To: City of Mercer Island – Plans Reviewer
Subject: Remodel – 5330 Butterworth Rd.
Building Permit # 2405-053

Thank you for reviewing our permit submittal. Below is a narrative of the plan updates and responses to the review comments we've received.

LOWER FLOOR	7,403	SQ. FT.
MAIN FLOOR	8,575	SQ. FT.
UPPER FLOOR	3,051	SQ. FT.
<b>TOTAL FINISHED</b>	<b>19,029</b>	<b>SQ. FT.</b>
SPORT PAVILION (TOTAL FINISHED)	2,542	SQ. FT.
GARAGE (WITH BRACKETS)	2,276	SQ. FT.
DECKS (WITH BRACKETS)	64	SQ. FT.
MECHANICAL (104 S.F. HANGDOWN HOODS FLOOR 4.F.)

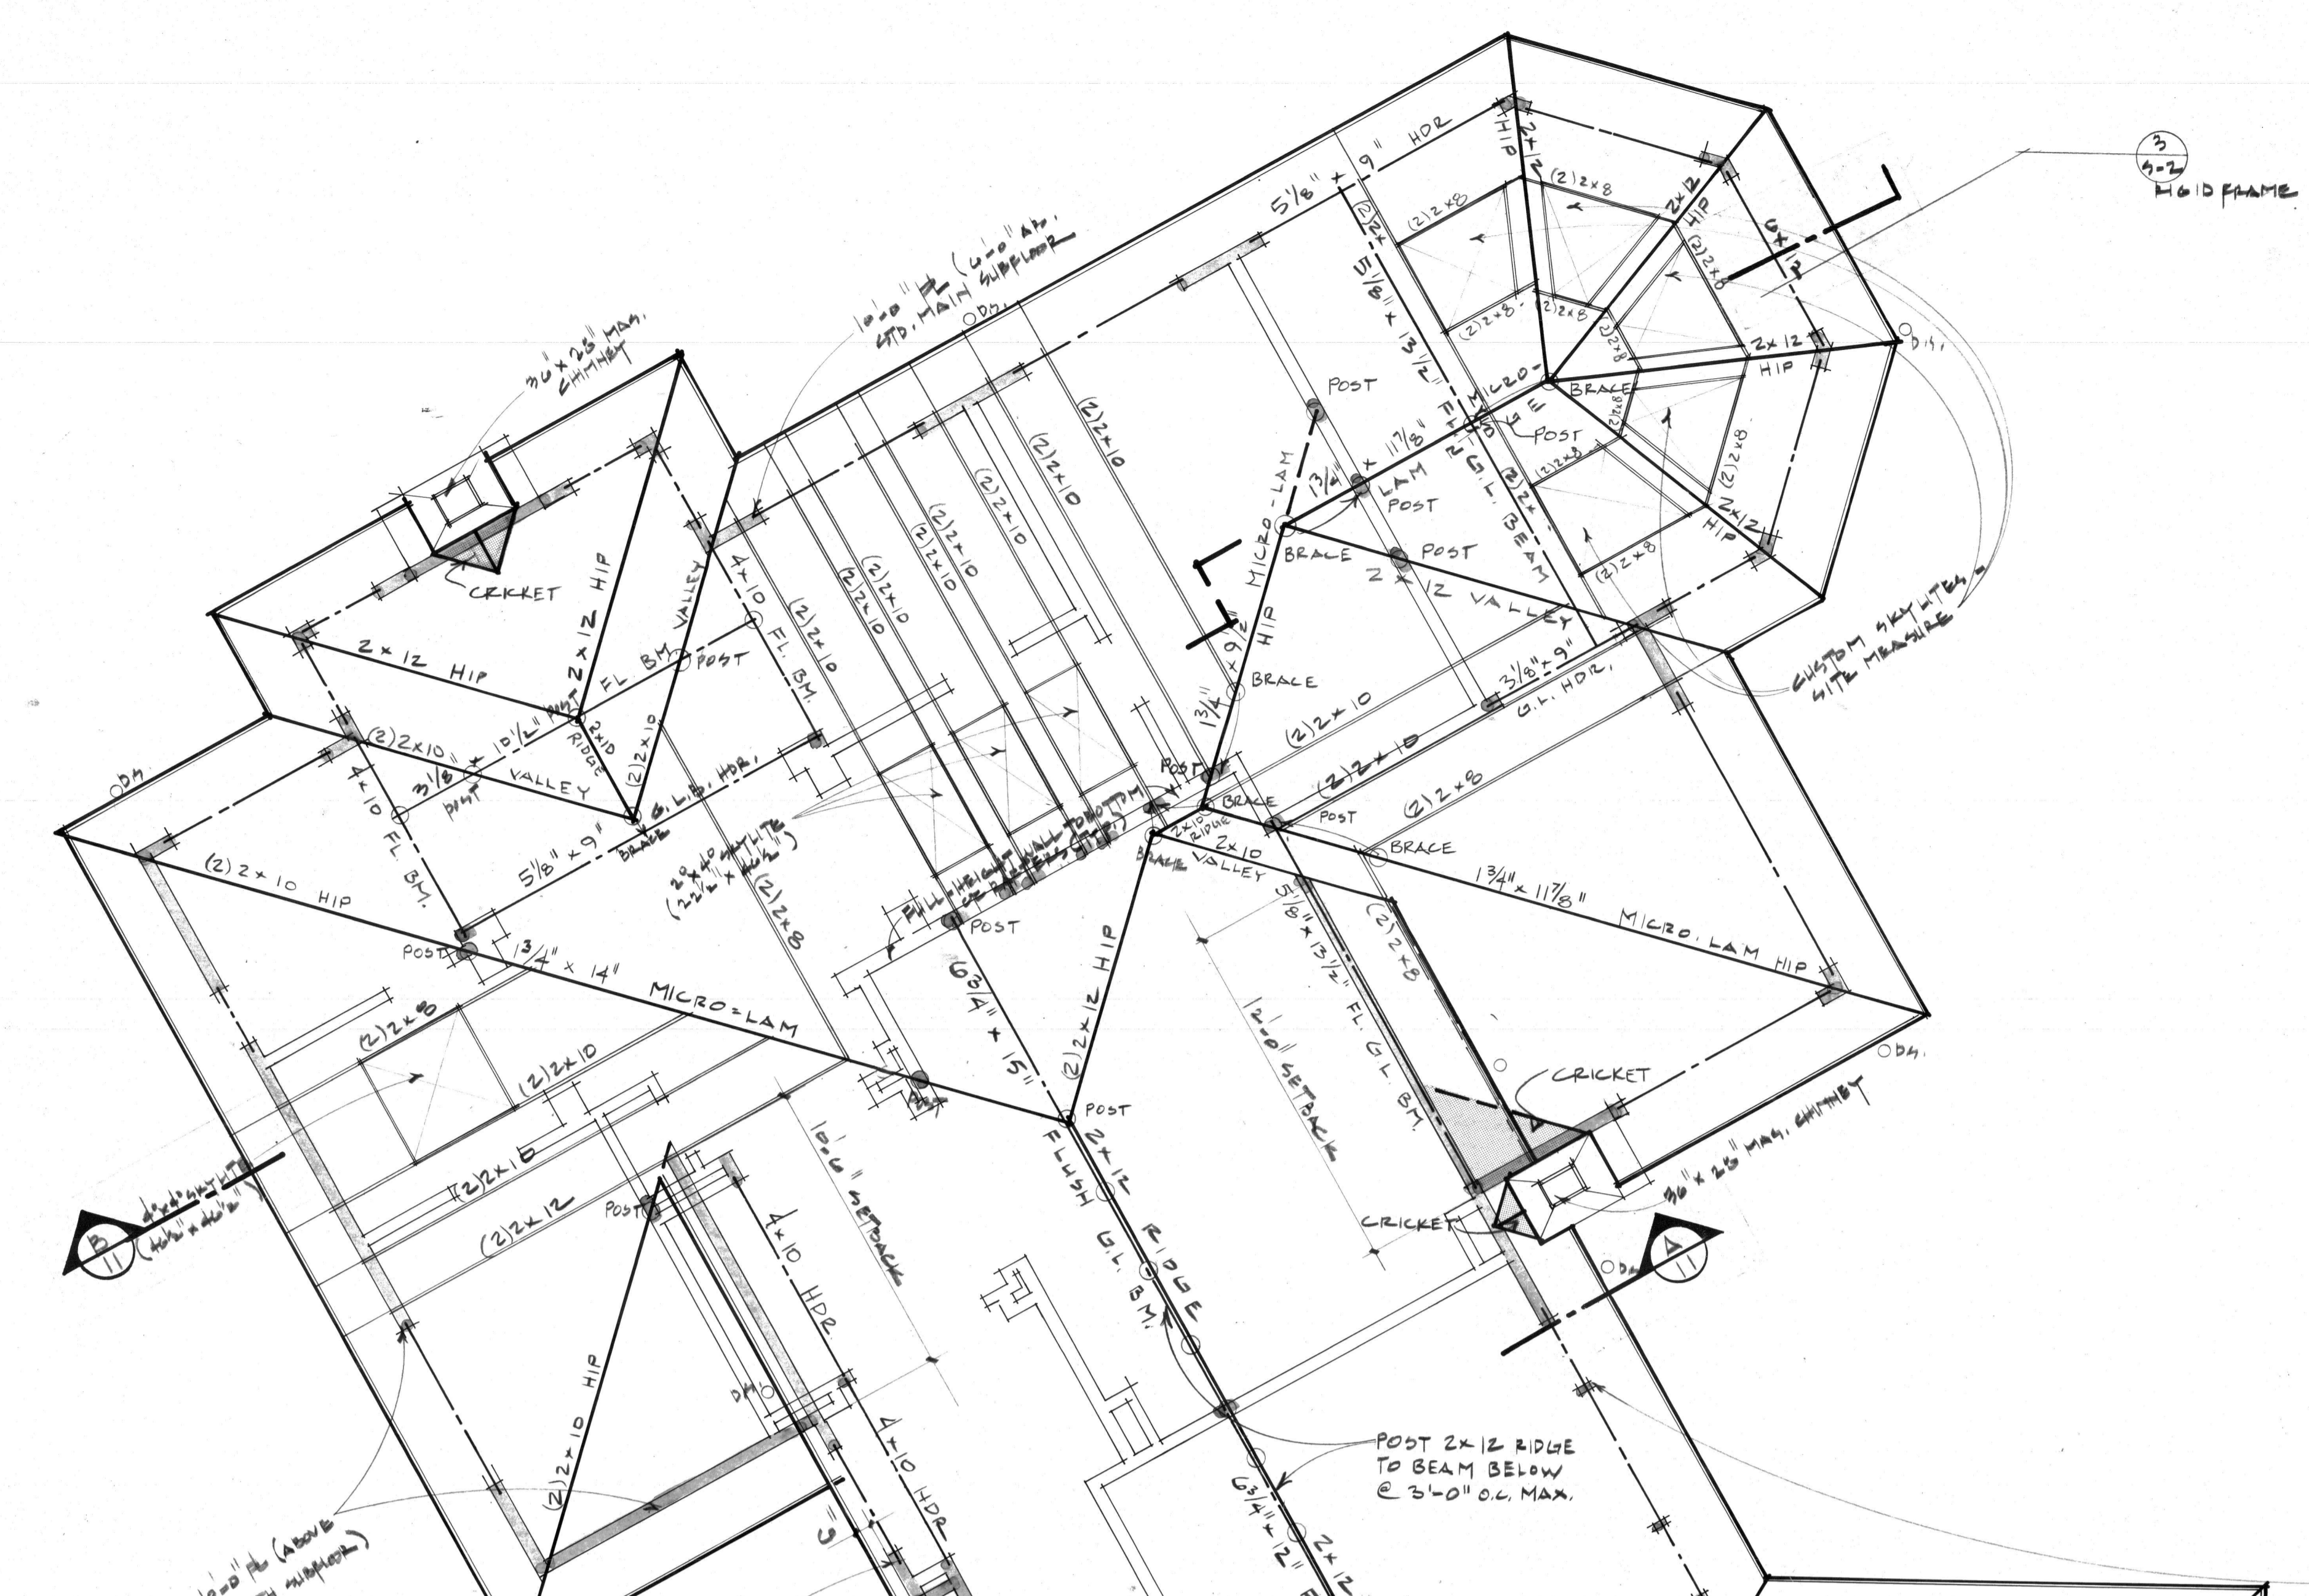
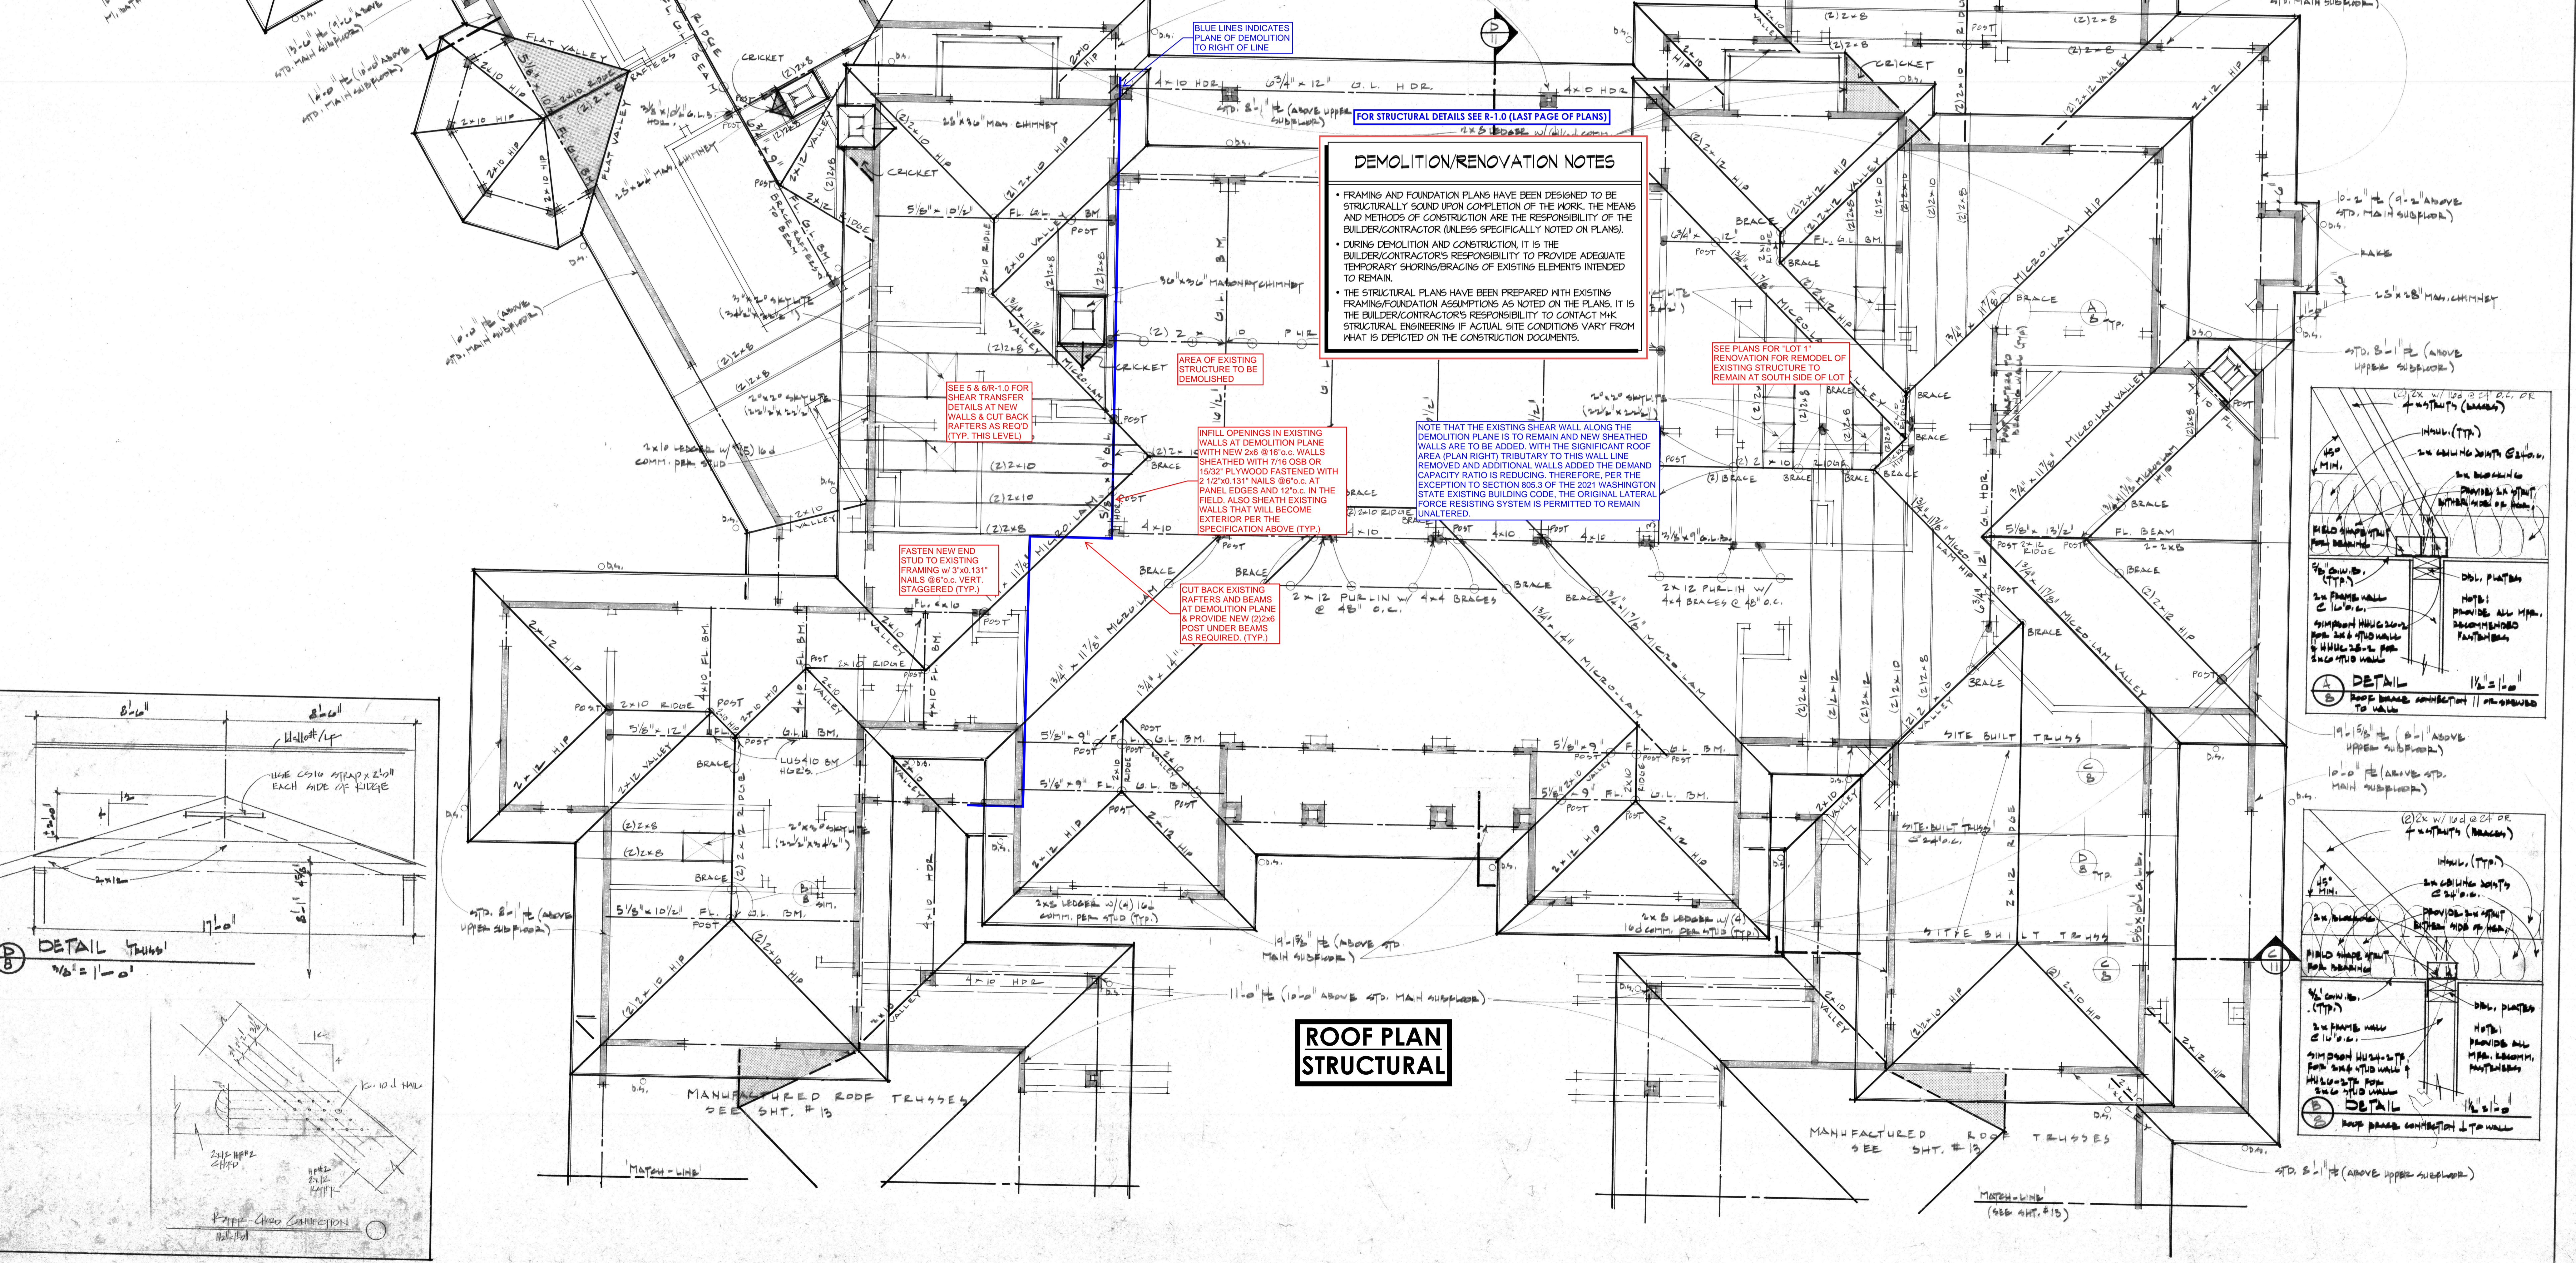
2) The project appears to divide the existing residence into two structures. Provide complete floorplans for the entire residence to scope the project (if where there are no changes to the north wing, mark rooms as existing to remain or not in scope). Provide complete details for the, structure, enclosure, insulation, and weatherproofing of the remaining north structure including lateral design if appropriate. Site plan provided does not describe the final condition... the site plan A1.0 at the end of the set shows features to be demolished.

[RESPONSE: Full plans for the existing house have been uploaded to the portal with notes and markups indicating scope of work. Structural details and notes have been provided indicating final condition.](#)
